PUD PRELIMINARY PLAN  
GRANDVIEW RESERVE FILING 1

EASTONVILLE RD  
EL PASO COUNTY, PEYTON, CO 80831

LANDSCAPE OVERVIEW  
PLAN

## Landscape Plan Enlargement

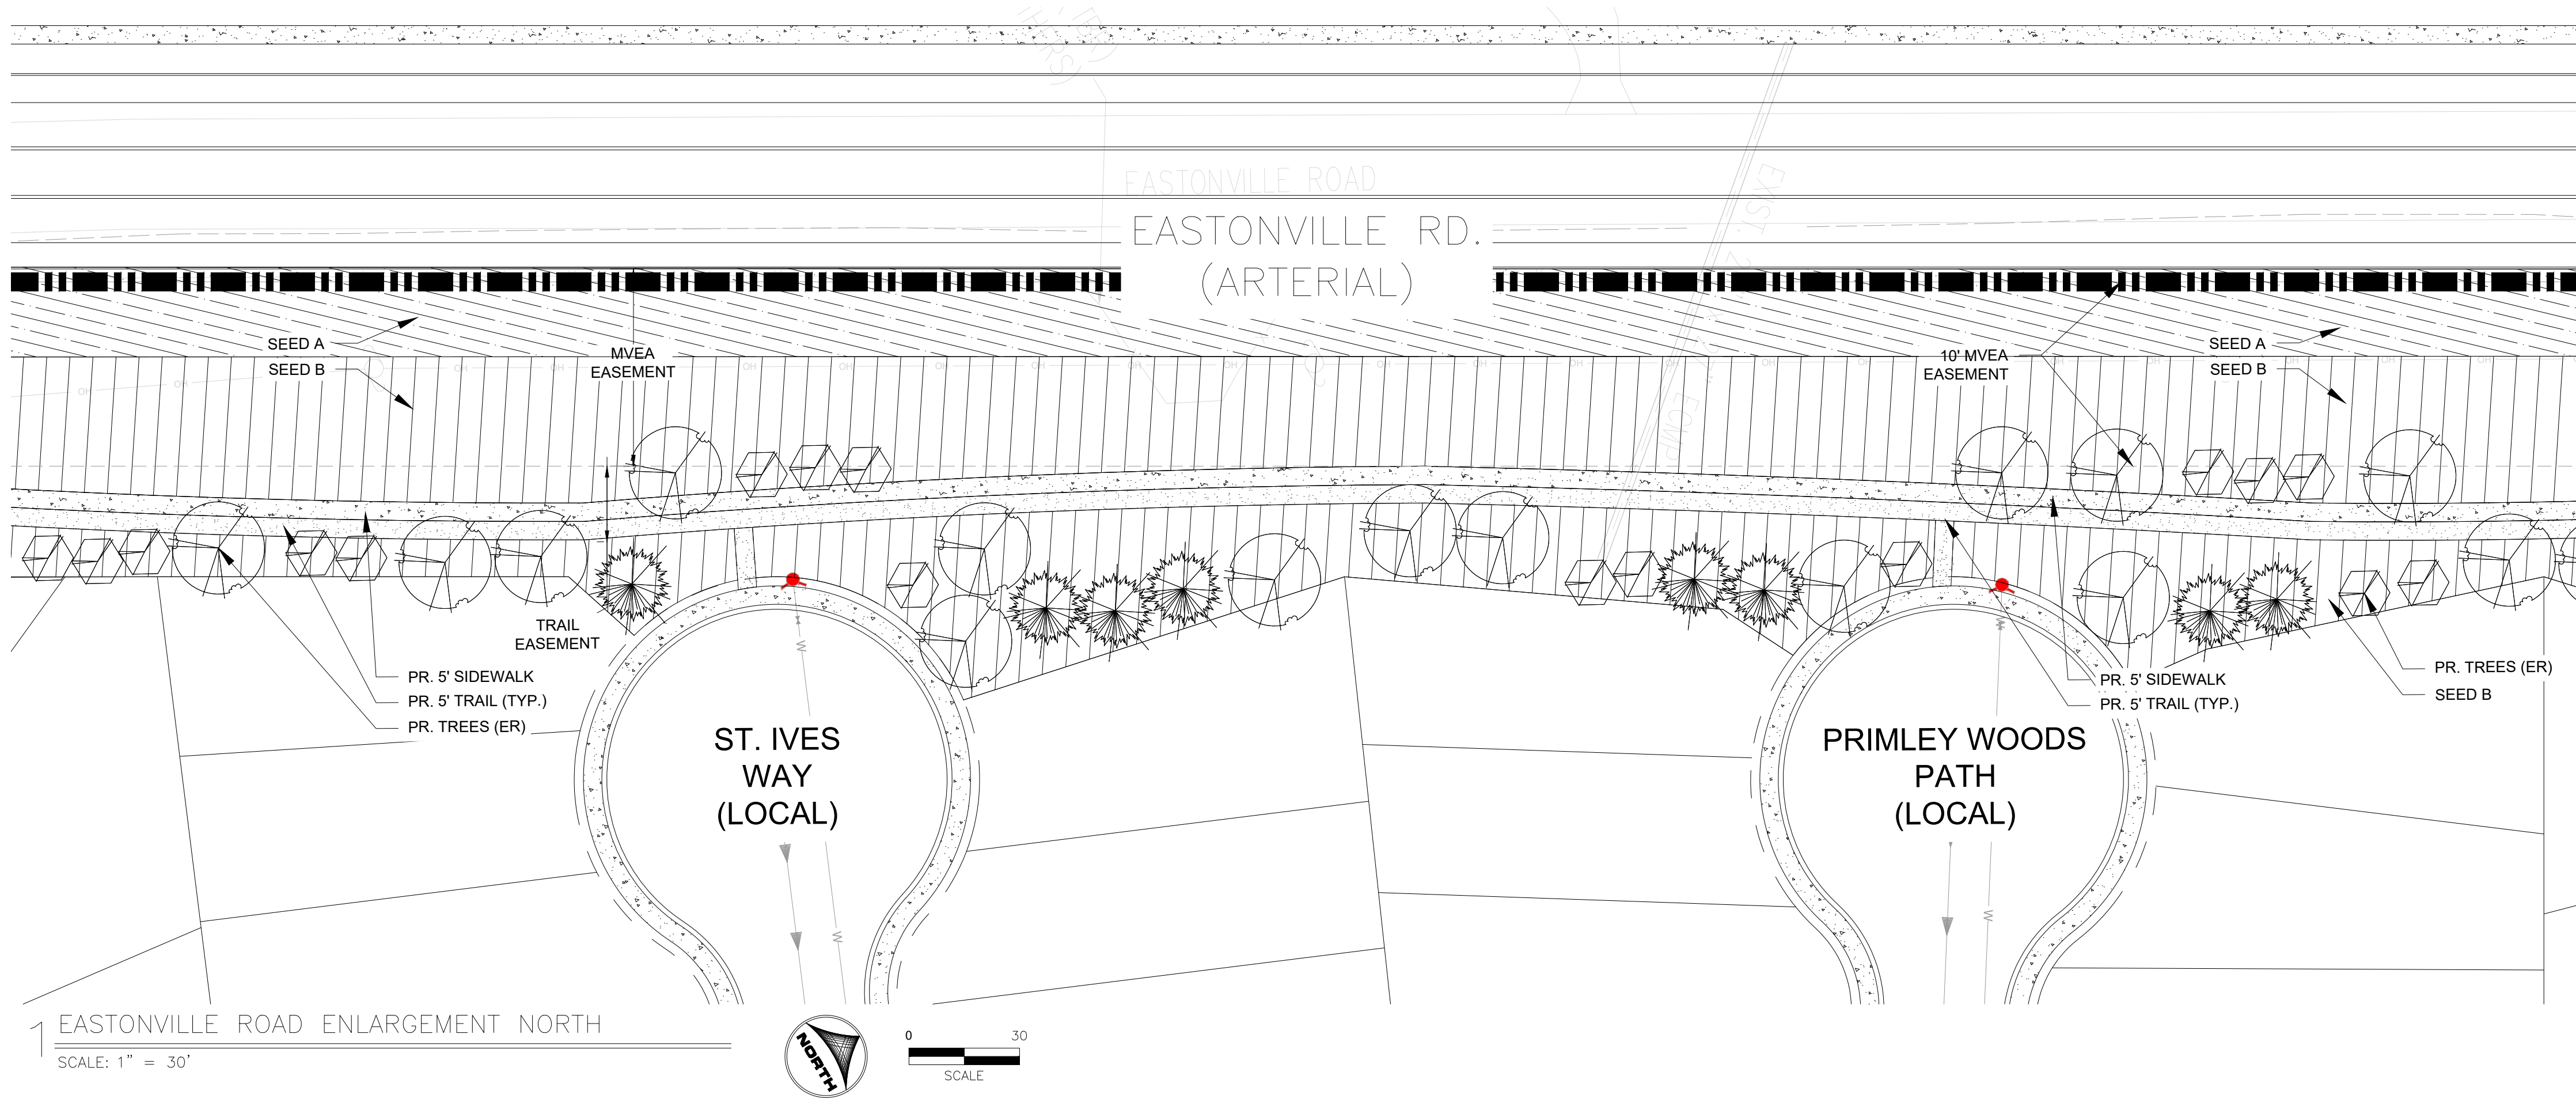
Perhaps -Pull trees back? Are you stating you are not electing to place any landscape along Eastonville? That is a modification...Is there fencing along Eastonville or Rex? Provide detail

HRG Response:  
Trail has been revised to meander within 30' easement leaving a 5' width of MEUA easement unobstructed. Tree requirements for Eastonville Road are met within this easement. Plan enlargements are provided.
